From: 
Sent: 24 September 2013 11:51
To: Charlotte Hardy
Cc: Joanna Allatt
Subject: RE: BR/201/13/DOC - 3 Marine Drive West, Bognor Regis

"At least 10% of the energy supply of the development shall be secured from decentralised and renewable or low carbon energy sources (as defined in the Glossary of the National Planning Policy Framework). Details and a timetable of how this is to be achieved, including details of physical works on site, shall be submitted to and approved in writing by the Local Planning Authority prior to the commencement of development. The approved details shall be implemented in accordance with the approved timetable and retained as operational thereafter, unless otherwise agreed in writing by the Local Planning Authority."

4. ON-SITE RENEWABLE ENERGY SOURCES

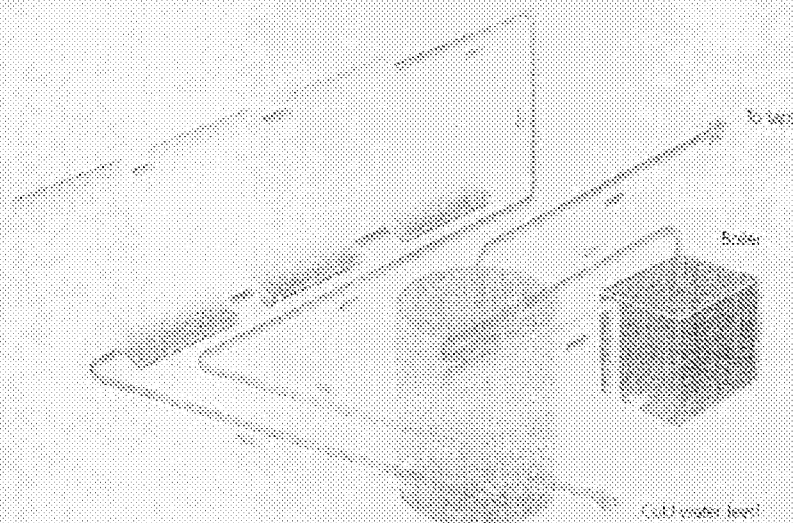
Overall I have issues in terms of the figures that they have within the Energy Statement in that I am unable to come out with the same figures. Also when looking at both the energy statement and the Kingspan leaflet about the intended systems I get confused with the information, or lack of it, that has been provided. In the Energy Statement they discuss solar hot water systems but state in the recommendation that it would be impractical in terms of the

pipework to the lower levels and in terms of only providing 6% of the site energy requirement. In terms of Solar PV they leave the recommendation completely open ended. Logically from what they are saying it would seem that the amount of space means that it would not be possible, however they do not actually state that this is the case. As mentioned at the beginning in comparing what they then say about the air source heat pumps and what is in the information leaflet and the figures provided I am unable to confirm their recommendation. Furthermore when comparing the two, it would seem that the use of the gas boiler means they must be going down the route of a Bivalent and Integrated System. Again however they have not explained the situation in their Energy Statement and on the figures within it I am not able to confirm their recommendation as I am unable to get the same figures.

On a more personal note I feel that the option of solar water heating or PVs have discounted too easily. I feel that something potentially combining the two may create more guaranteed savings. Potentially this may be done through them being applied to only the number that are feasible (such as the top 2 flats specifically or 2/3 floors).

I would suggest that further clarification needs to be added into the Energy Statement and that the figures need to be sorted. As Jo has suggested, having the coefficients and/or ratios expected would be the most helpful thing in this respect.
